# CITY OF ALBUQUERQUE

**RE: Manzano Mesa Park Pickleball Courts  
Grading and Drainage Plan  
Engineer's Stamp Date 2-1-16 (File: L21D037B2)**

Based upon the information provided in your submittal received 2-2-16, the above referenced submittal is approved for Grading Permit. Furthermore, we have the following recommendations to consider:

MANZANO MESA PARK
PICKLEBALL COURTS
GRADING & DRAINAGE DETAILS

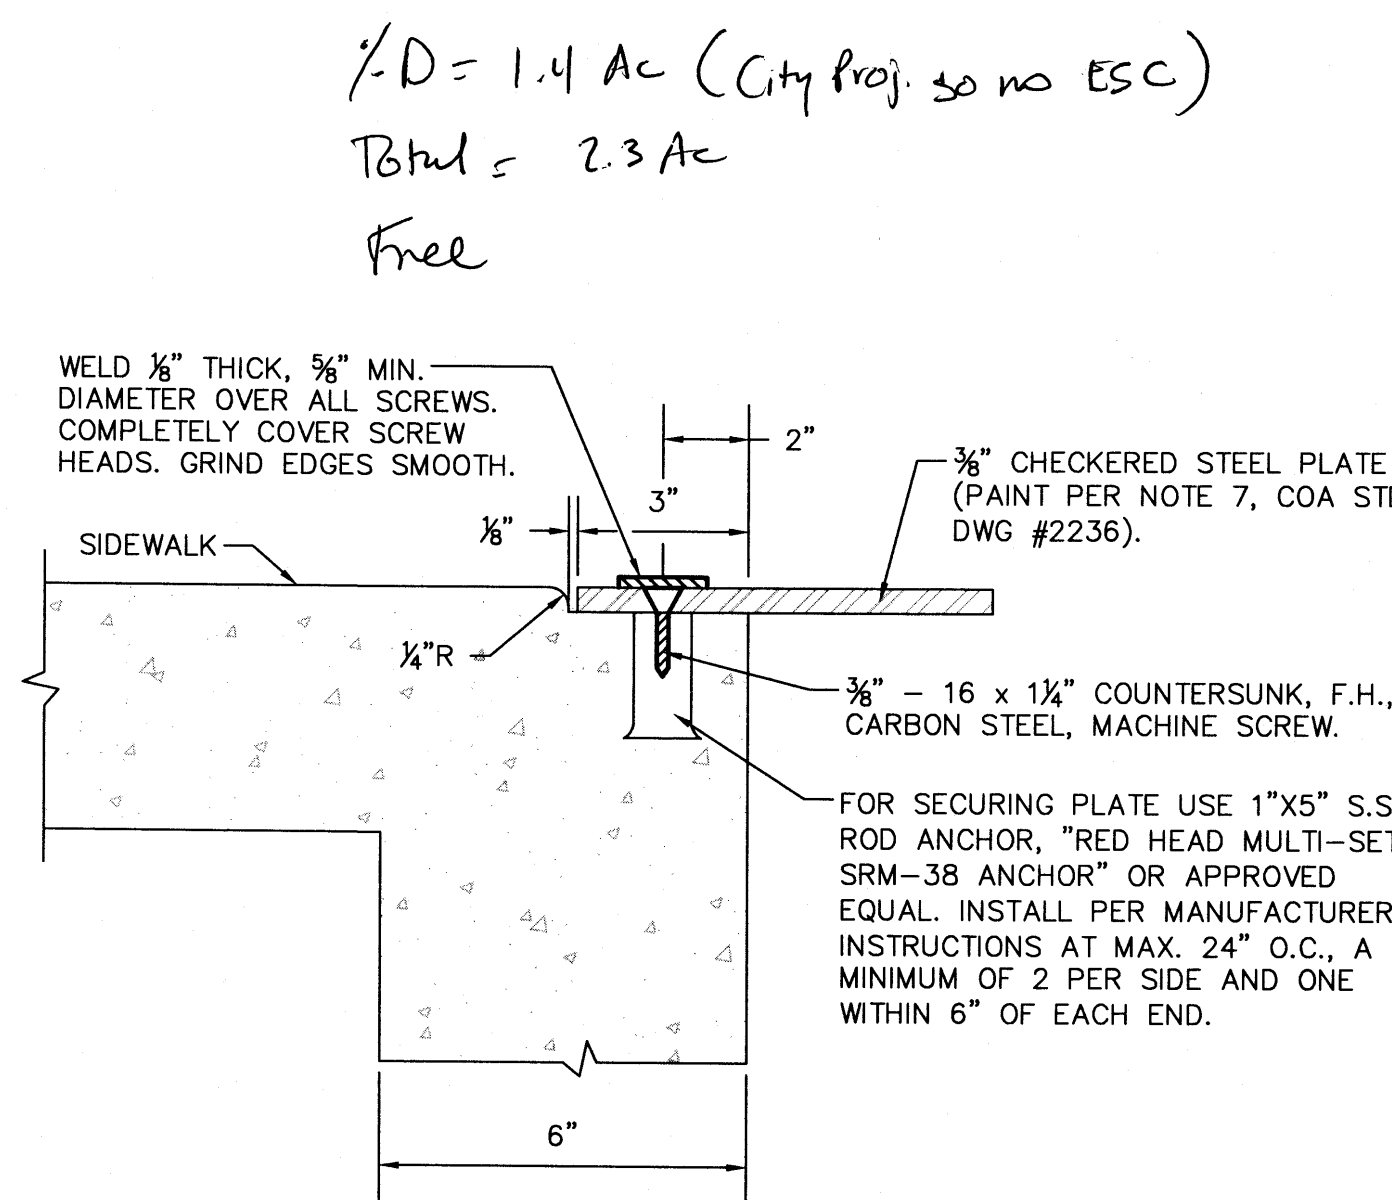
1. Consider an 18" sidewalk culvert (on Pond 2) to pass the approximately 7 CFS peak flow expected during the 100-year event. The 1-foot culvert appears to be acceptable, however, for the 2-year and 10-year events.
2. The City, as the lead of the project, might not be able to direct the contractor to sole-source drainage (or other) products (NDS, Geotex, etc). We recommend stating "or equivalent", or follow the guidance from the funding agency (if the project is federal or state funded).
